Emirates One&Only Wolgan Valley

Modification of Concept Plan and Project Approval (Helicopter trips and other changes)

Response to Submissions Report

15 December 2017
Rev00

Figure 2: Existing and proposed helipad locations and proposed bee hives location

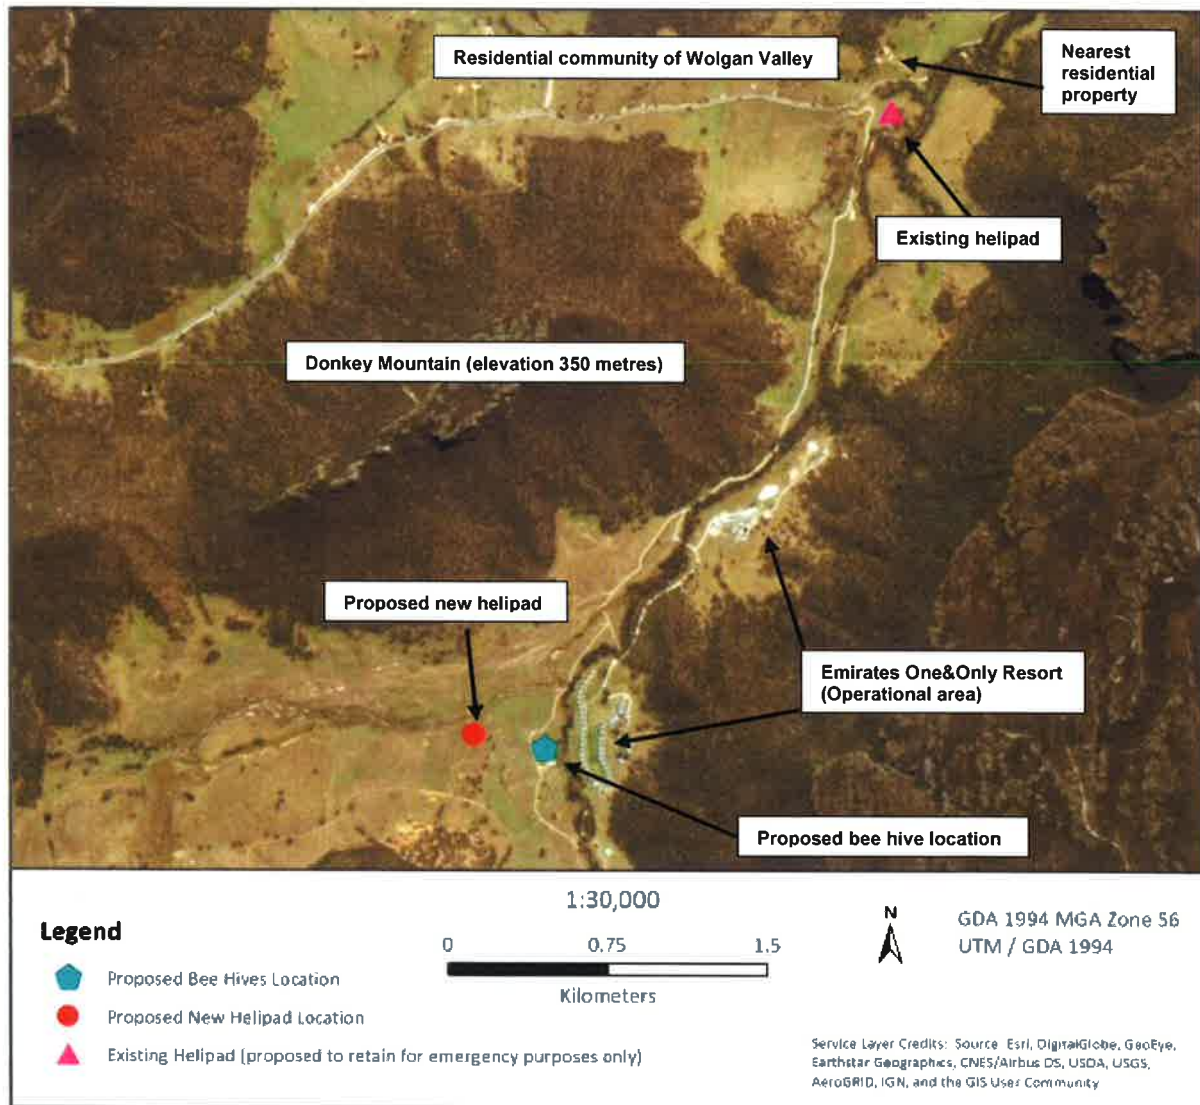
NSW Office of Environment & Heritage			
Flora	<p>OEH recommends that the proponent provide information specific to the new proposed helipad site regarding the flora species that are present and the condition state of the vegetation.</p> <p>If the proponent provides information to confirm that the vegetation at the proposed helipad site is non-native, then given the negligible impact of the proposed activity on biodiversity values this project modification should not require a biodiversity offset strategy.</p>	9	<p>On 30 November 2017, a flora survey was undertaken of the proposed helipad site and surrounds by ecologists at Western Sydney University (Old & Wolfenden, 2017). The full report is included in Appendix B. Four transects each 25m long extending out from the proposed helipad location and opportunistic flora surveys were undertaken.</p> <p>No 'rare', 'threatened' or 'endangered' plant species were identified. Two of the seventeen species identified in the area of the proposed helipad are considered native flora species (Bamboo grass and the Geranium species). Fifteen of the plants collected were identified as introduced pasture or 'weed' species, typical of cleared lands in the valley flats which have been used previously to graze cattle.</p>

NSW Department of Industry			
Bee hives	<p>The proponent should provide a layout plan indicating the proposed location of the bee hives to demonstrate that staff and guests are not likely to come in close proximity to them in the course of routine activities.</p> <p>The proponent should ensure that they are registered as a bee keeper through the Service NSW Portal and that bee hives are managed in accordance with the Australian Honey bee Industry Biosecurity Code of Practice.</p>	15	<p>As shown in Figure 6, the beehives would be located near the Wolgan Homestead within the heritage precinct, across the Wolgan River approximately 150m from the resort guest accommodation buildings.</p> <p>The Australian Honey Bee Industry Council (AHBIC) has developed a national Biosecurity Code of Practice (the Code). The resort will follow the Biosecurity Manual for Beekeepers Version 1.1 January 2016 guidelines, which contain best practices for caring for and managing hives to reduce the risk of exotic and established pests affecting honey bees.</p>

While cattle were removed about 10 years ago, the site is currently heavily grazed by macropods and wombats, as evidenced in [Figure 7](#) and [Figure 8](#), and therefore the site would be expected to remain largely unchanged in terms of plant species.

The proposed location for the helipad is a historically disturbed site, and continues to harbour mostly agricultural and exotic flora species that continue to be grazed by macropods and wombats. The proposed location for the helipad site is considered suitable and its proposed use would have negligible impact to biodiversity values and not require a biodiversity offset strategy.

Figure 4: Proposed flight paths

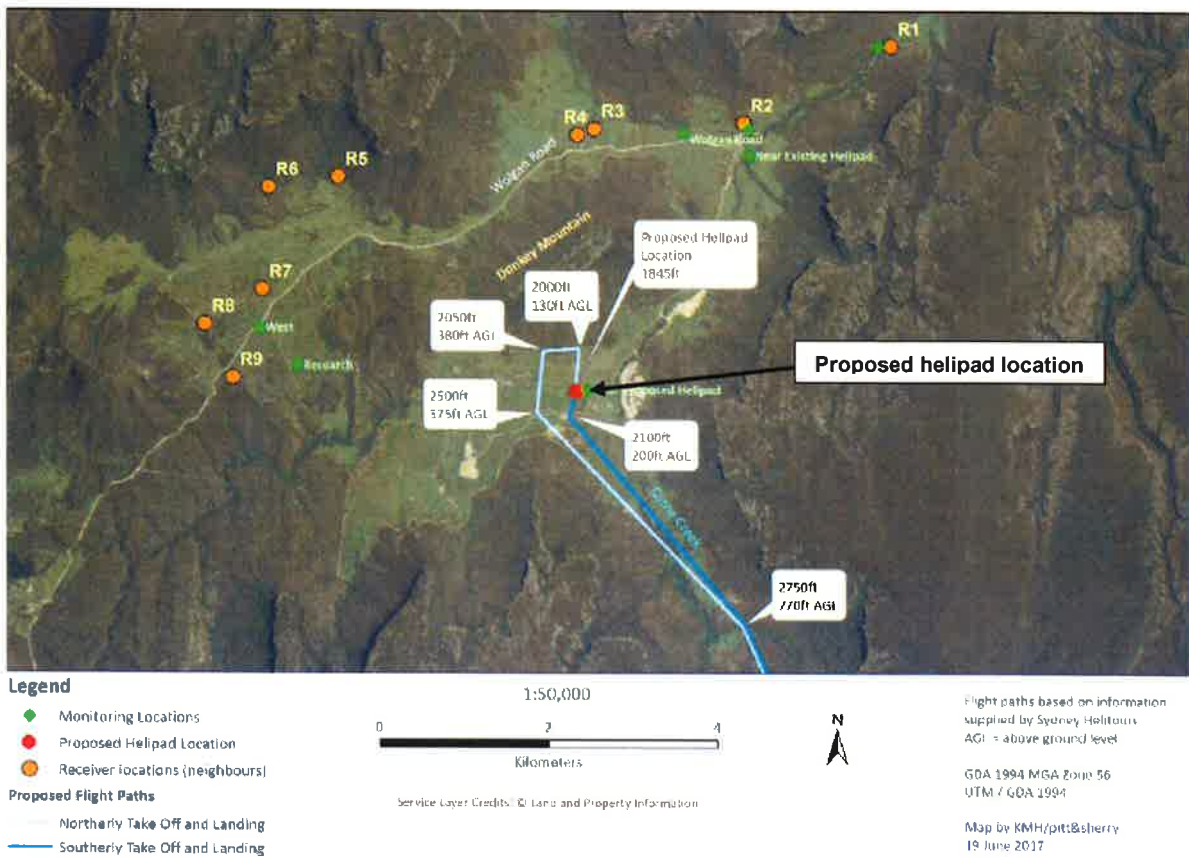
Helicopter flight paths	<p>The Colong Foundation has the following types of concerns in relation to the helicopter flight paths and trips:</p> <ul style="list-style-type: none"> The rate of climb on departure and descent for each helicopter type is not provided, therefore helicopter behaviour on the proposed departure and approach flight paths cannot be understood. Descent and ascent using Carne Creek canyon is contrary to the FNA and will cause intrusive noise and helicopter activities at the scenic lookouts above the gorge and at Dry Canyon camp in Wollemi National Park. The resort’s Operational Management Plan should include helicopter operations management measures to avoid annoying park users, impacts to wilderness areas and birds, and avoid bird hazards. The flights paths down Carne Creek canyon are below cliff top level and inappropriate due to bird strike risks. The approach and departure routes in Carne Creek canyon is a mid-air collision hazard and should be reconsidered and brought to the attention of the Federal Civil Aviation authorities. Dry Canyon in Wollemi National Park is used for camping. It should be flagged in the EIA and FNA as an environmentally sensitive site. Flight levels stipulated in the FNA should be applied from the cliff tops or the helicopter operator should keep 600 metres away from cliff edges during descent/ascent. 	28	<p>As discussed in Response # 2, all commercial flights to and from the resort are conducted by Sydney HeliTours under an exclusive contract with the resort. HeliTours operates under its own Air Operators Certificate (AOC) #1-D90FL-03, are a Civil Aviation Safety Authority (CASA) Certified Air Carrier, and are regularly audited by CASA for compliance with relevant aviation safety and procedural regulations.</p> <p>Flight paths would follow those shown in Figure 2. Flight paths outside of this distance would vary due to originating airport (e.g. Bathurst versus Sydney), but the approach and departure will always use the proposed flight paths. Arriving aircraft will favour the western side of the valley and departing aircraft will favour the eastern side of the valley.</p> <p>As discussed in Response # 7, the resort and Helitours are committed to ensuring adherence to the FNA in recognition of the enduring amenities of the Greater Blue Mountains World Heritage Area and the Wolgan Valley, one of the primary draws for resort customers and National Park users alike. Adherence to the FNA has been included in the Supplementary SoC and in the updated contract between the resort and Helitours.</p> <p>The location of the proposed helipad and flight paths would increase the lateral separation from the Dry Valley camping ground compared to the flight paths for the current helipad. The helicopter operational heights to be flown on approach and departure to and from the proposed helipad are shown in Figure 2. The helicopter flight paths would be no less than 2.0km laterally from the campground whilst above the escarpments.</p> <p>HeliTours pilots conduct operations in compliance with the Elstone Pty Ltd (Sydney Helitours) Operations Manual. Procedures included in the manual are “Look Out and See” as well as “Bird/Animal Avoidance” (refer vFS.5 Volume 2 Part B – Standard Operating Procedures in section 2B1.17).</p> <p>Sydney HeliTours and the resort will not conduct scenic joy flights as part of One&Only Wolgan Valley.</p> <p>Sydney HeliTours conducts all operations under the approval of the Civil Aviation Safety Authority including all applicable CAR’s CAO’s, CASR’s as well as the AIP and En-Route Supplement Australia. Flight paths and operational heights to and from Wolgan Valley have been approved by CASA and designed to exceed the FNA for the Blue Mountains National Park unless operationally required due to Air Traffic Control or stress of weather.</p>

Helicopter trips / movements and flight paths	The Blue Mountains Conservation Society has the following types of concerns in relation to the helicopter flight paths and trips: <ul style="list-style-type: none"> Use of an increase in approved helicopter trips to establish "joy flights". Demand for helicopter flights to and from the resort will continue to increase and create incremental and progressively more frequent helicopter trips into the future. The approach and departure routes in Carne Creek canyon is a mid-air collision hazard and should be reconsidered in light of the proposed increase in flights. No information regarding helicopter-type and departure and descent characteristics was included, thus further comment on flightpaths is not possible. 	35	Sydney HeliTours and the resort will not conduct scenic joy flights as part of One&Only Wolgan Valley. The proposed limits to helicopter trips account for the current and projected demand for helicopter transport to and from the resort. As discussed in detail in Response #28, Sydney HeliTours conducts all operations under the approval of the Civil Aviation Safety Authority including all applicable CAR's CAO's, CASR's as well as the AIP and En-Route Supplement Australia. Flight paths and operational heights to and from Wolgan Valley are shown in Figure 2 and have been approved by CASA and designed to exceed the FNA for the Blue Mountains National Park unless operationally required due to Air Traffic Control or Stress of Weather. The type of helicopter Helitours currently uses is the EC130. It is possible that Helitours may invest in the Eurocopter EC135 version of the EC130.
